Thank you for the opportunity to comment on Block 4N at Central Park.

Submission for Job: #6673 Block 4N - Central Park, Mixed Use Development

Sheet No. 43 of 104
01 West Elevation - Abercrombie

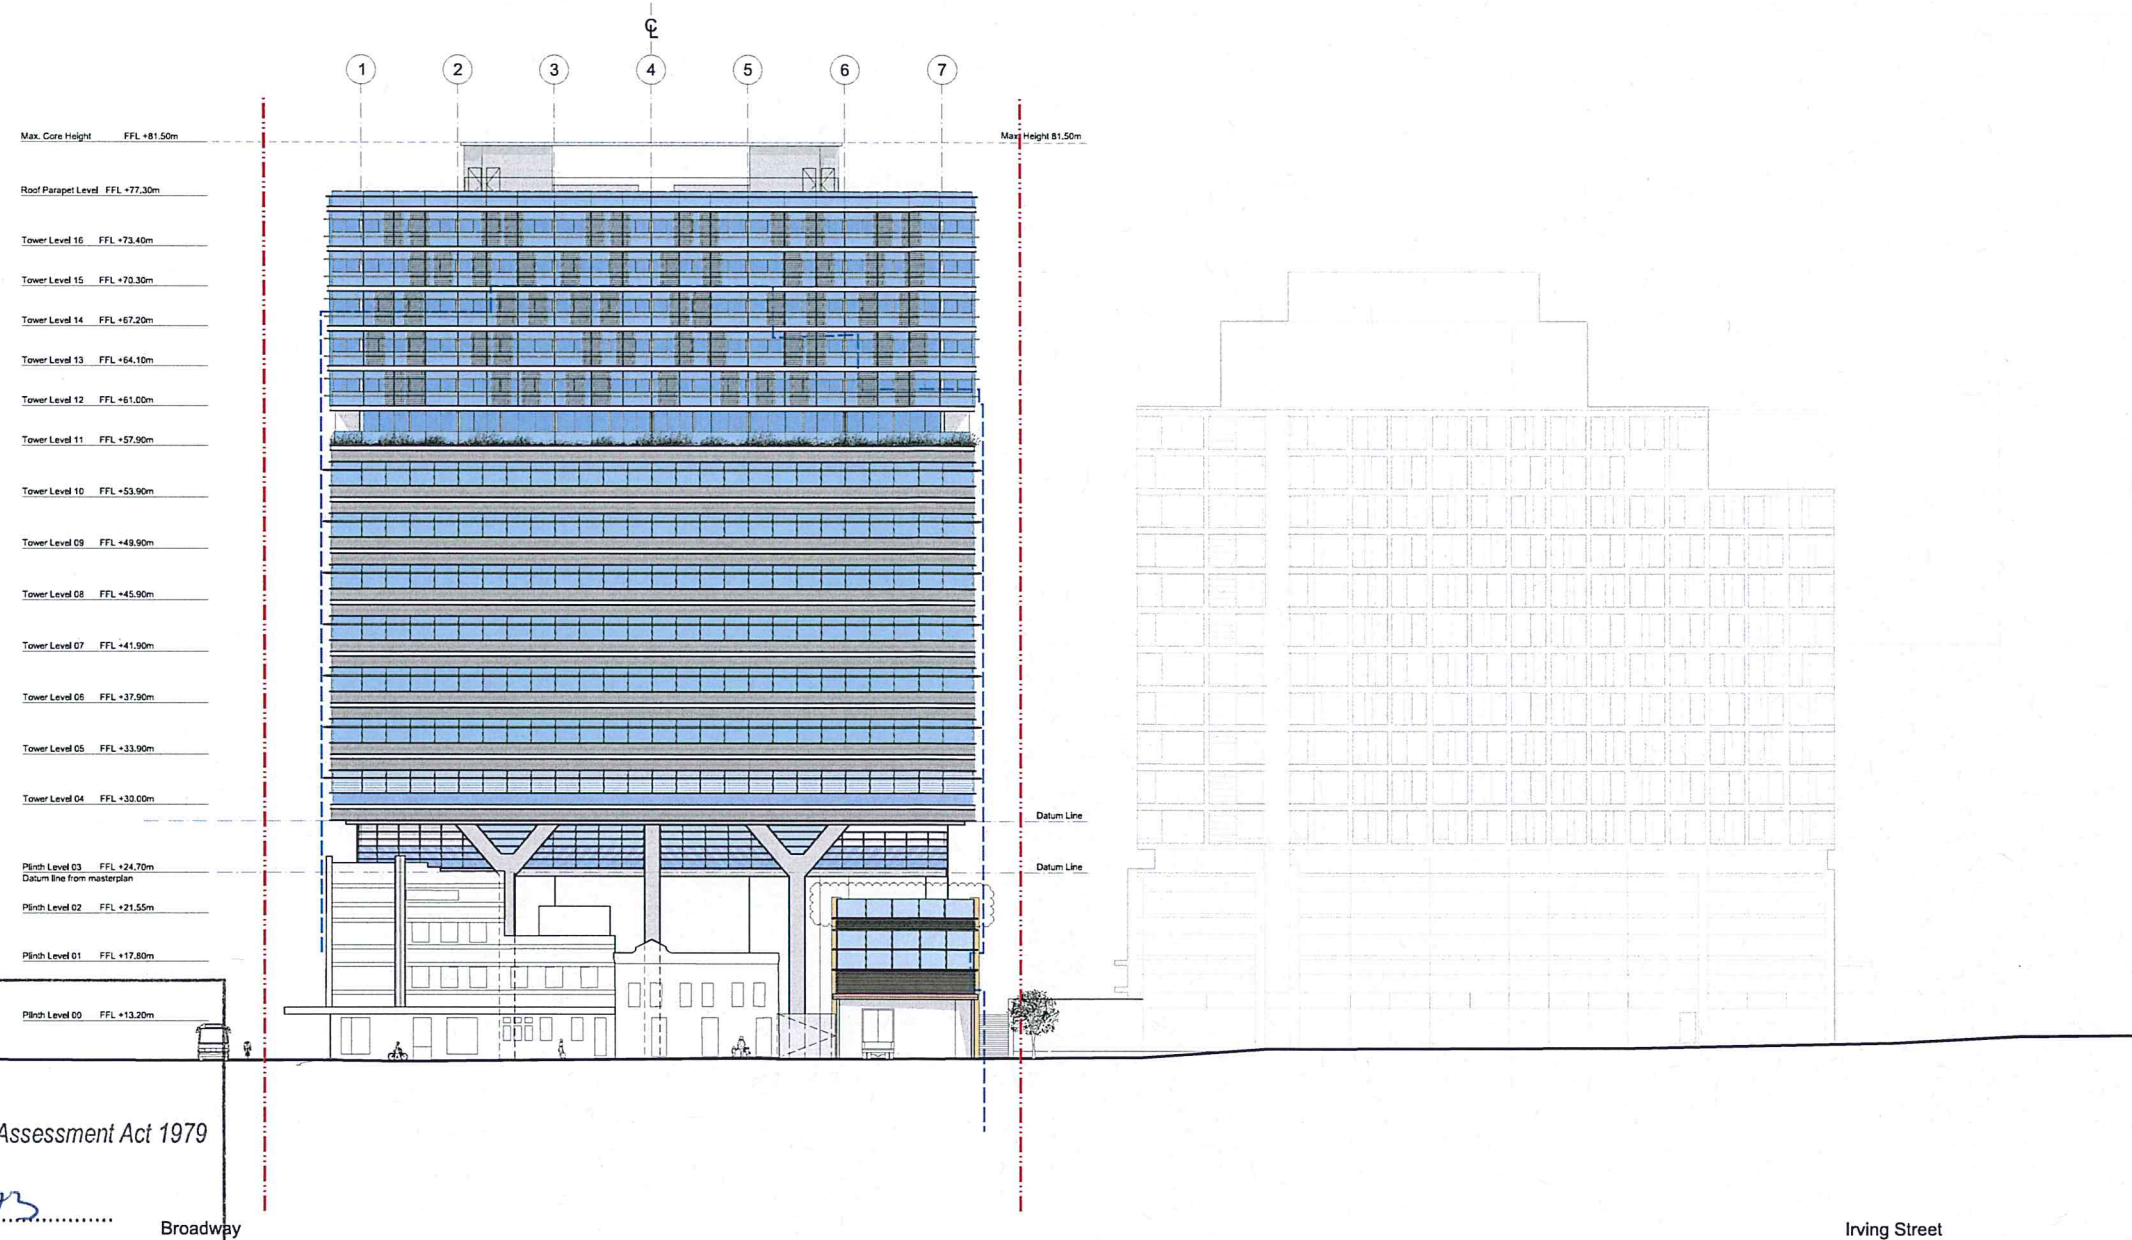
That said, there is an opportunity to improve the definition of Abercrombie Street through modification to the proposed podium building to their south.

The use of brick and sanstone to create a more strongly defined street to the south of the Abercrombie Street Terraces would enhance the area's sense of place and improve the balance between the relative densities of Central Park and Notre Dame. It would better connect the facade of the neo-Gothic building that defines most of the Abercrombie Street facade to Central Park, and avoid the Abercrombie Street corner being isolated aesthetically from the rest of the street.

The facade of the podium level proposed is defined by strong horizontal elements in glass and metal, whilst the building opposite on Abercrombie Street is defined by its vertical bays whose spacing provide a rhythm for the street. Although the art deco pub, the Australian Hotel/Abercrombie Hotel, has a strong horizontal element due to its art deco styling, it and the terraces still retain a vertical bay structure which mean that the street is more defined by its verticality.

1. Podium level of 3-4 stories to align with the height of the top of the Abercrombie Hotel/Australia Hotel and the height of the buildings across the road at Notre Dame.
2. Use of appropriate facade materials such as polychrome brickwork, sandstone, and render in a complimentary and sympathetic palate.
3. Continuation of the rhythm of the bays that the windows provide down Abercrombie St to knit the two sides of the street together.
